Your Ref: OWPC19036
Our Ref: FG/100/18/HH 15-05-2018
Please ask for:
Pat Aird

Retention of 1.8m high trellis fence to front boundary.
2 Sea Lane Gardens Ferring

Site Plan

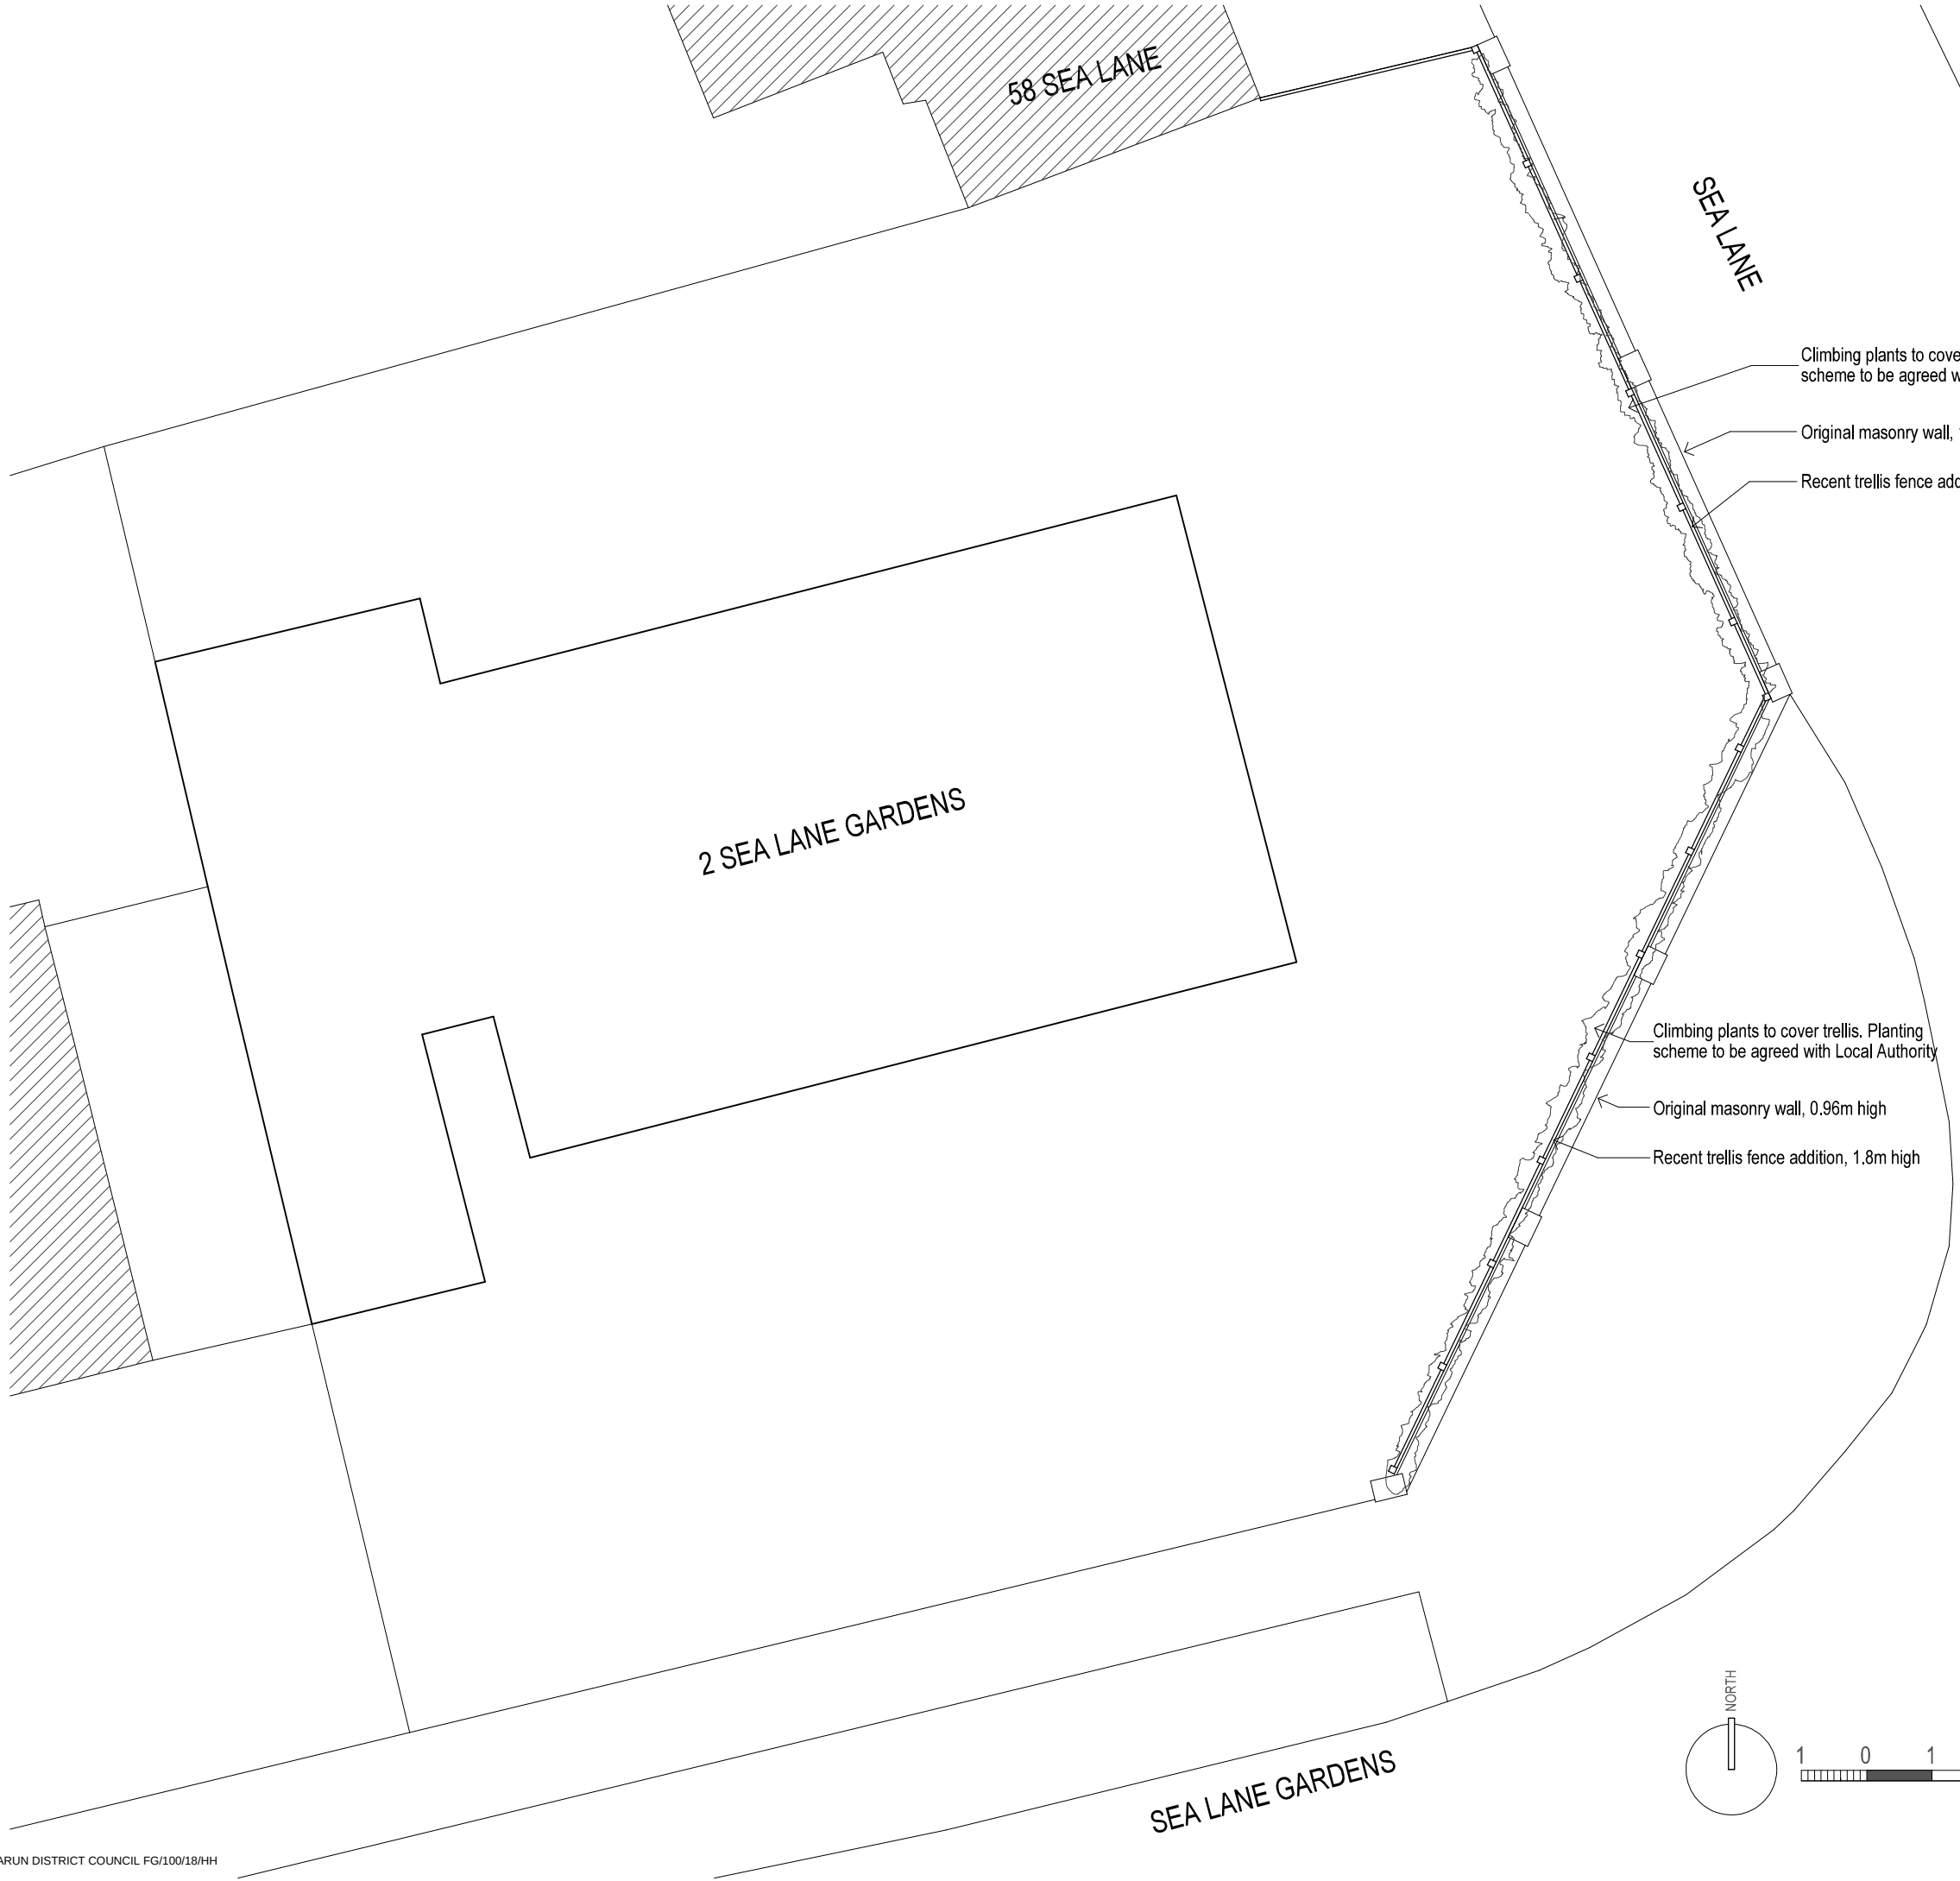
*Objection to height of fencing. Appearance is not in keeping with surrounding frontages and cottages.
Fencing may impede the view of the road for pedestrians and drivers as it is placed near to a bend in the road (Sea Lane). Residents of neighbouring properties have to step directly into the road when crossing Sea Lane as there is no pavement, and the turn out from Sea Lane Gardens is already hazardous due to the amount of traffic, and number of speeding vehicles.*
